**Addendum No. 1**

RE: Contract # C204507

**Cumberland County (U-5798A)**

SR-1102 FROM NORTH OF SR-1112 TO US-401 AND REPLACE BRIDGE  
250075 OVER LITTLE ROCKFISH CREEK.

<b>PROJ. REFERENCE NO.</b>	<b>SHEET NO.</b>
U5798A	X-1B

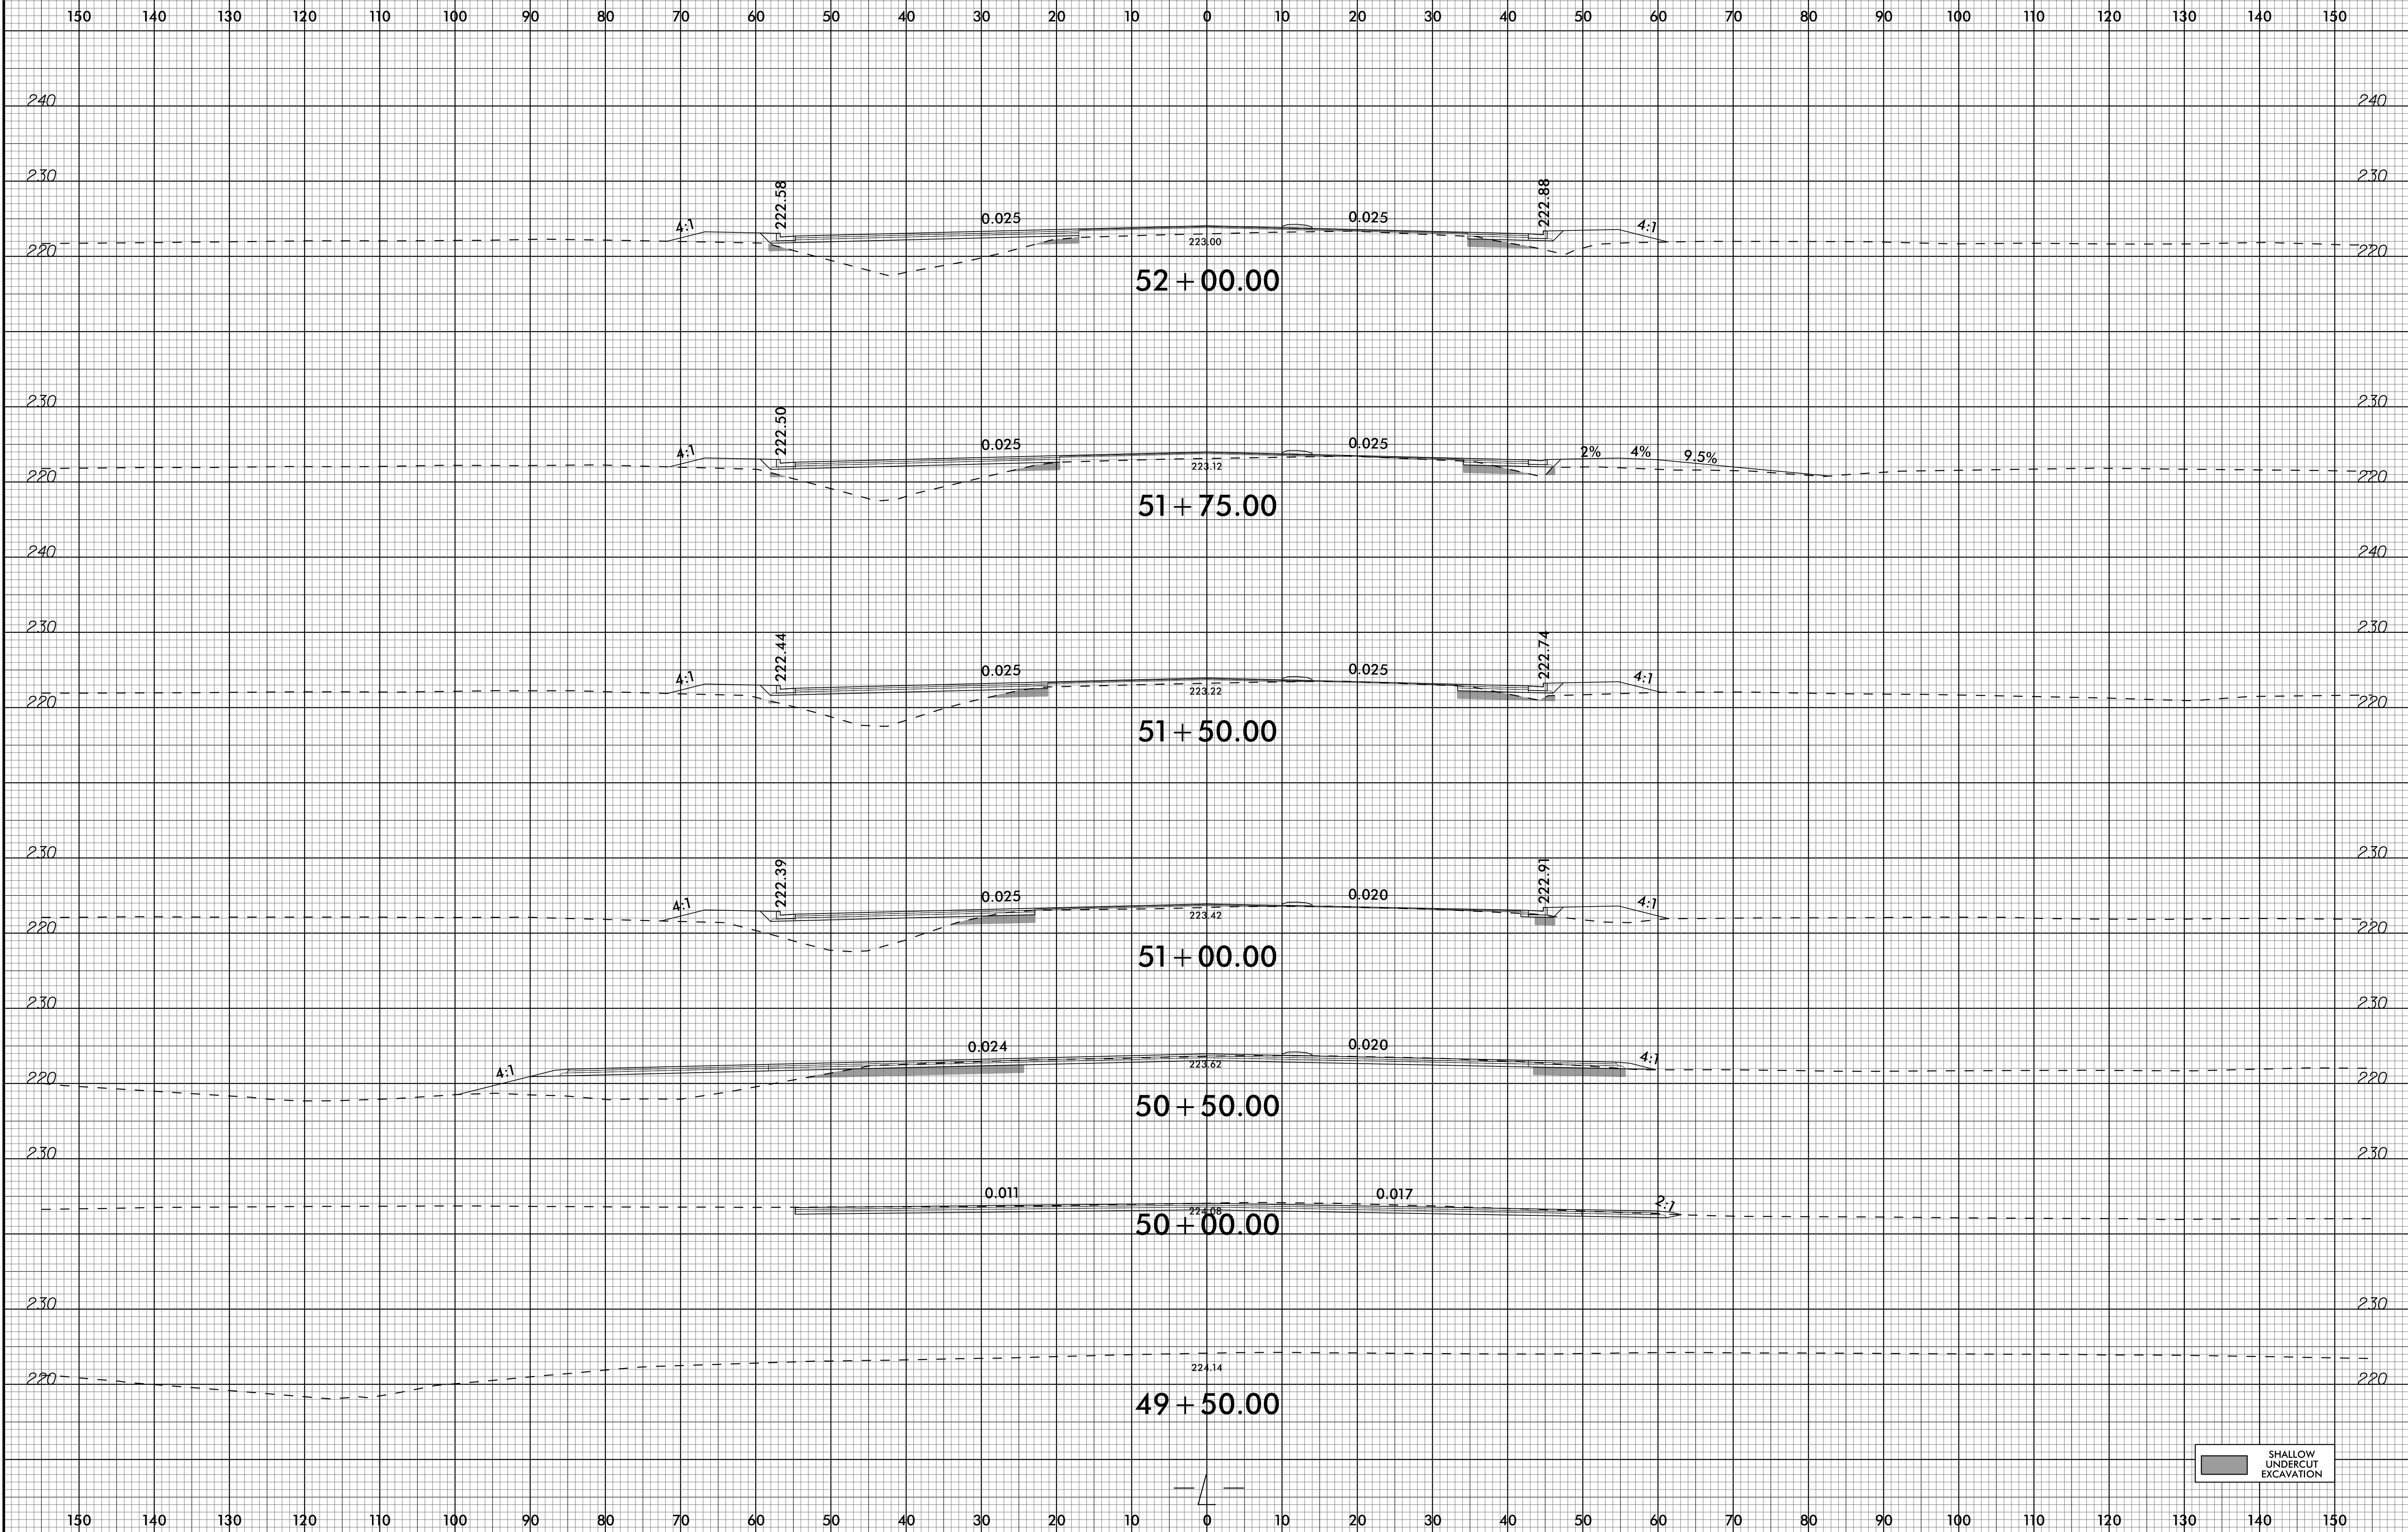
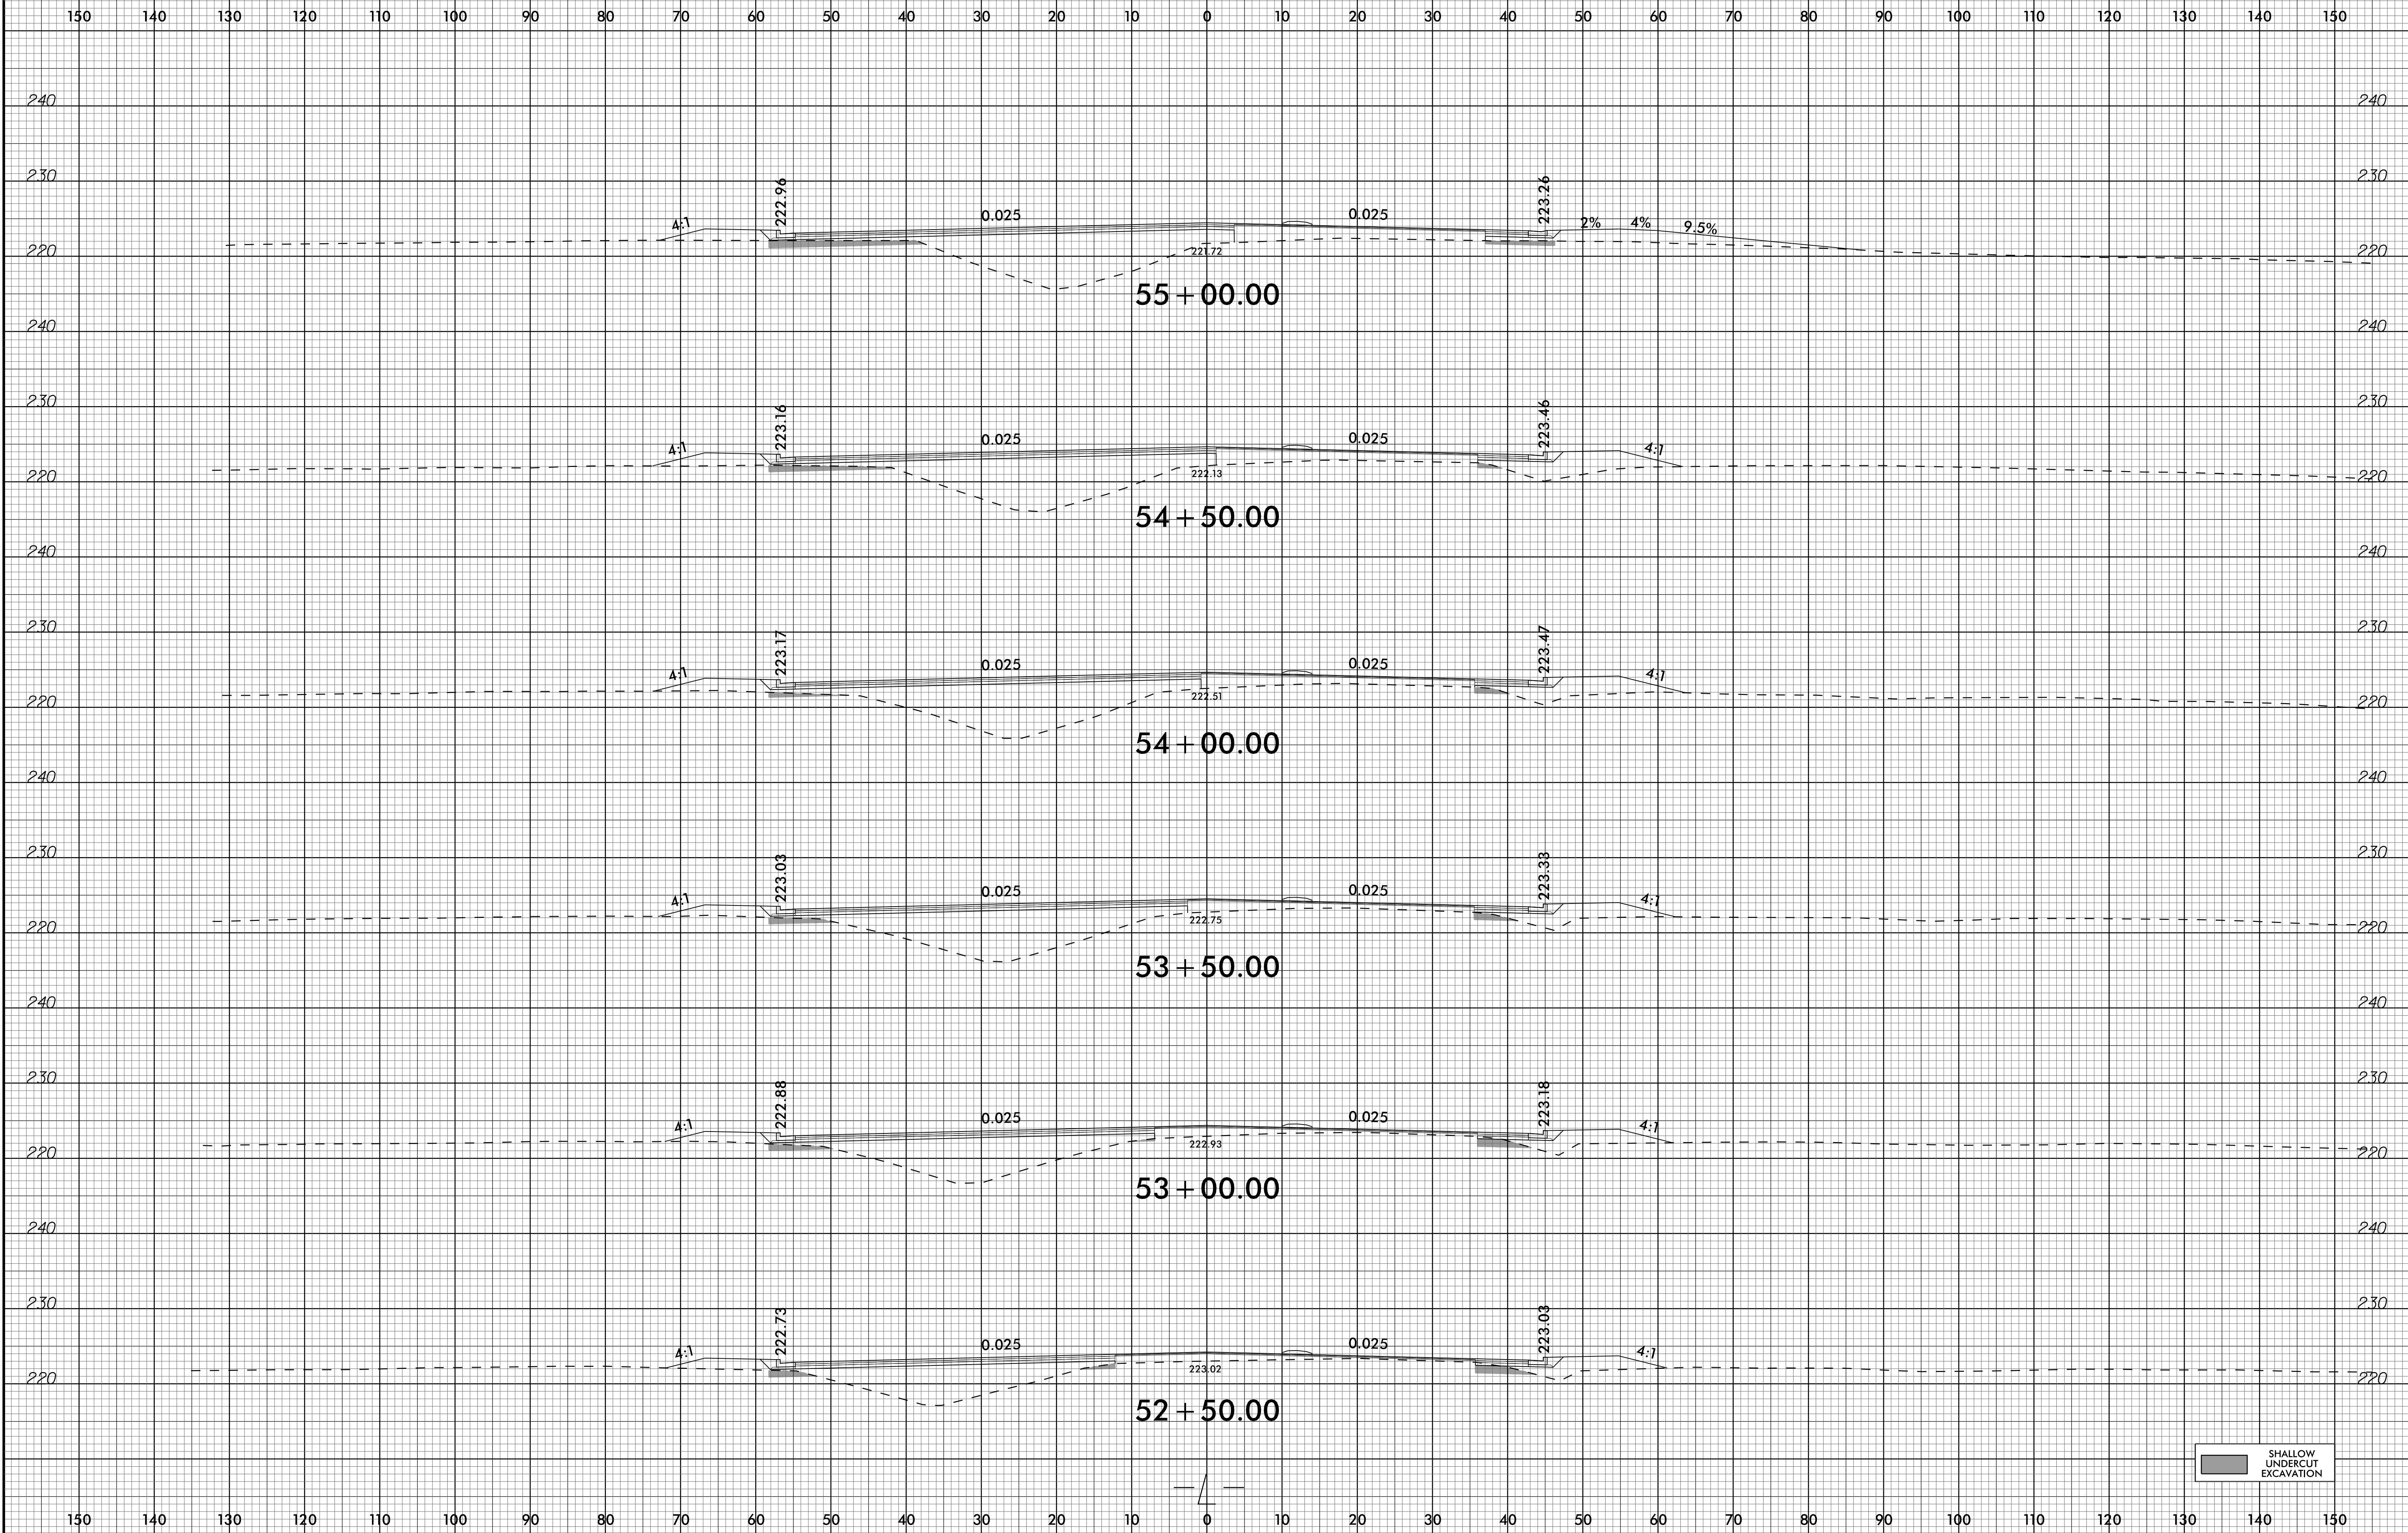
Sheet No.	Revision
X-1B	Updated to reflect changes in Grading items.
X-1C	Updated to reflect changes in Grading items.
